Submission No.			281	
Organisation Name or Name of Submitter			Sinead Quilty (39 Estuary Court, Seatown Road, Swords, Co Dublin)	
Item No.	Section Ref.	Page No.	Observation Statement	TII Response
Letter Re: Case 314724: Estuary through Swords, Dublin Airport, Ballymun, Glasnevin and City Centre to Charlemont, Co. Dublin (MetroLink)				
1	Observation Comments	1	<i>Re. construction of new pathways with associated landscaping and a signalised pedestrian crossing of the R132 and on land adjacent to R132 connecting Estuary Court & Seatown Villas -</i> The existing vehicle and pedestrian access to Estuary Court meets the access requirements of the residents of Estuary Court. Removing the existing boundary wall to creating new pathways into Estuary Court from the R132 does not fulfil any access gaps or requirements. It also creates a unsafe zone for children of the Estuary Court estate (and) creates an unsafe area along the R132 for cyclists, pedestrians and vehicles as young children and children’s toys (e.g. footballs) may travel at speed out onto the R132 without any warning.	<u>Landscape Reinstatement</u> Acknowledging your concerns, TII is committed to working with local resident’s g

Drawing Title	METROLINK - GENERAL ARRANGEMENT SEATOWN (SHEET 1 OF 3)		Drawing Status	S1
Drawing N°	ML1-JAI-ARD-ROUT_XX-DR-Y-03012	Plan Drawing N°	ML-RO 301 H-J	
Scales Original Size A1	AS SHOWN	Sheet	1	of 1

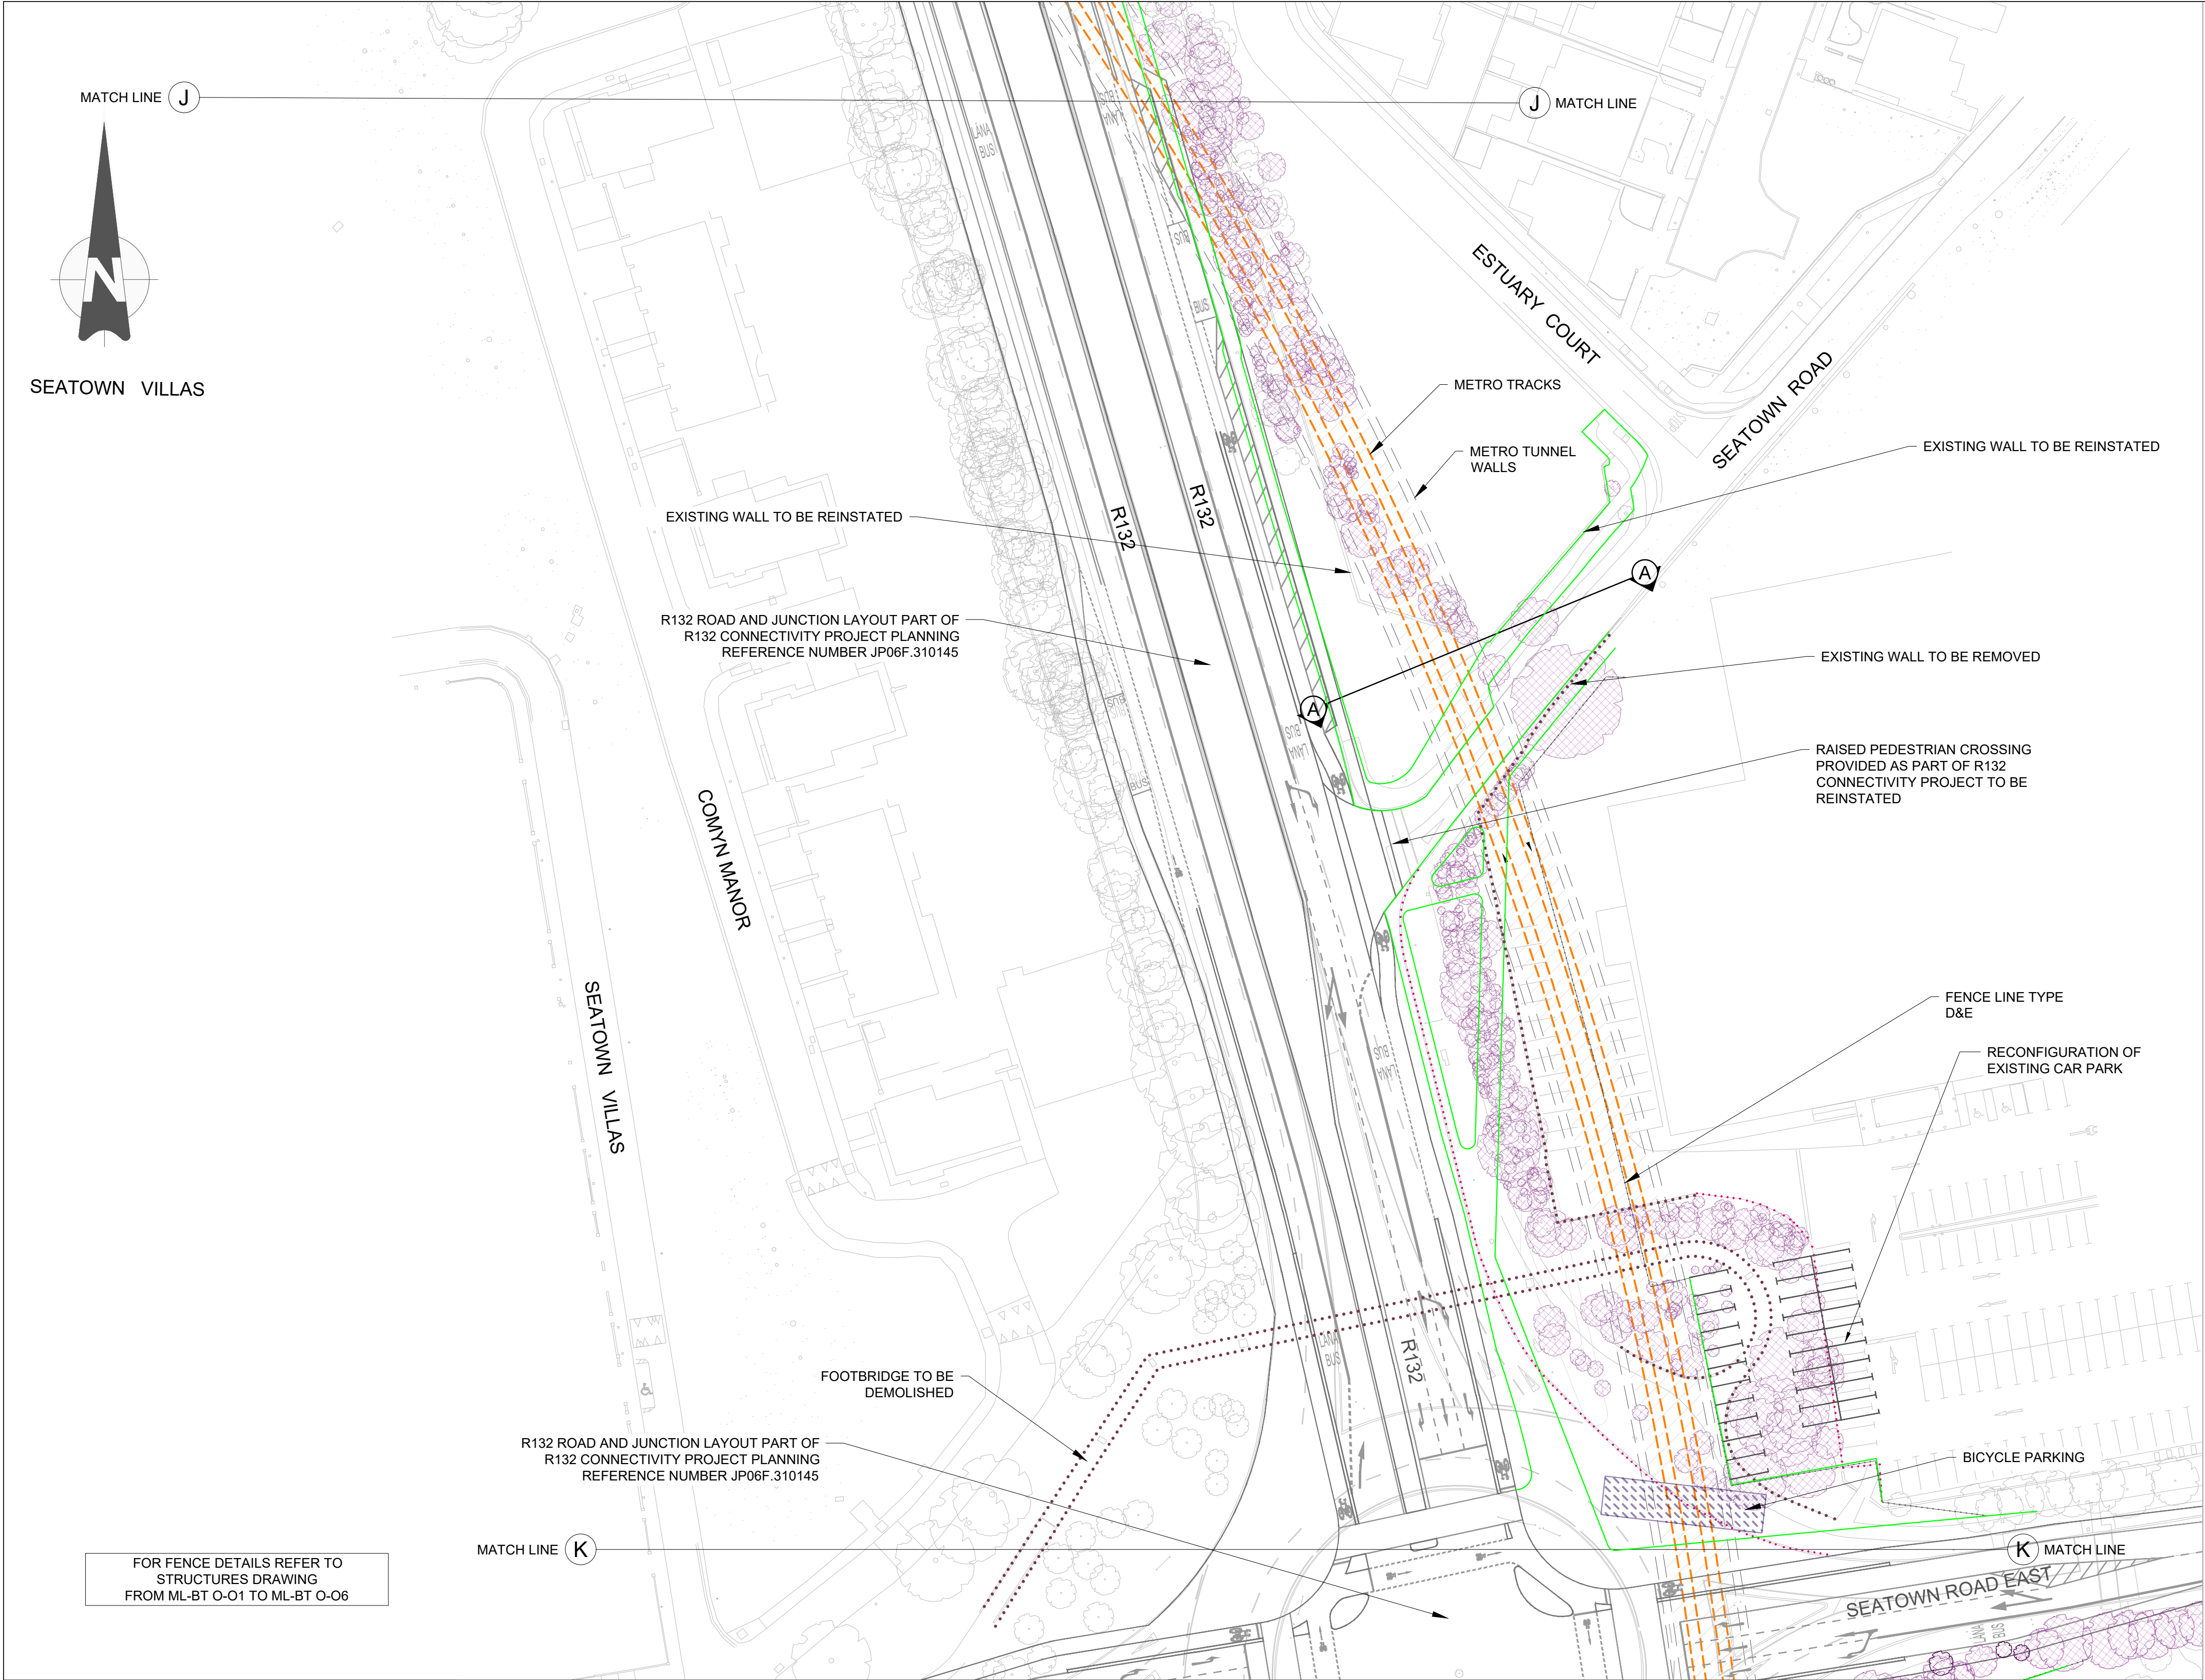
2	Observation Comments	2	<i>Re. construction of new pathways with associated landscaping and a signalised pedestrian crossing of the R132 and on land adjacent to R132 connecting Estuary Court & Seatown Villas -</i> Reinstating the existing wall without adding unnecessary additional entrances to the Estuary Court would remove this liability and greatly enhance the life of the residents of Estuary Court.	Please see Response (1) above.
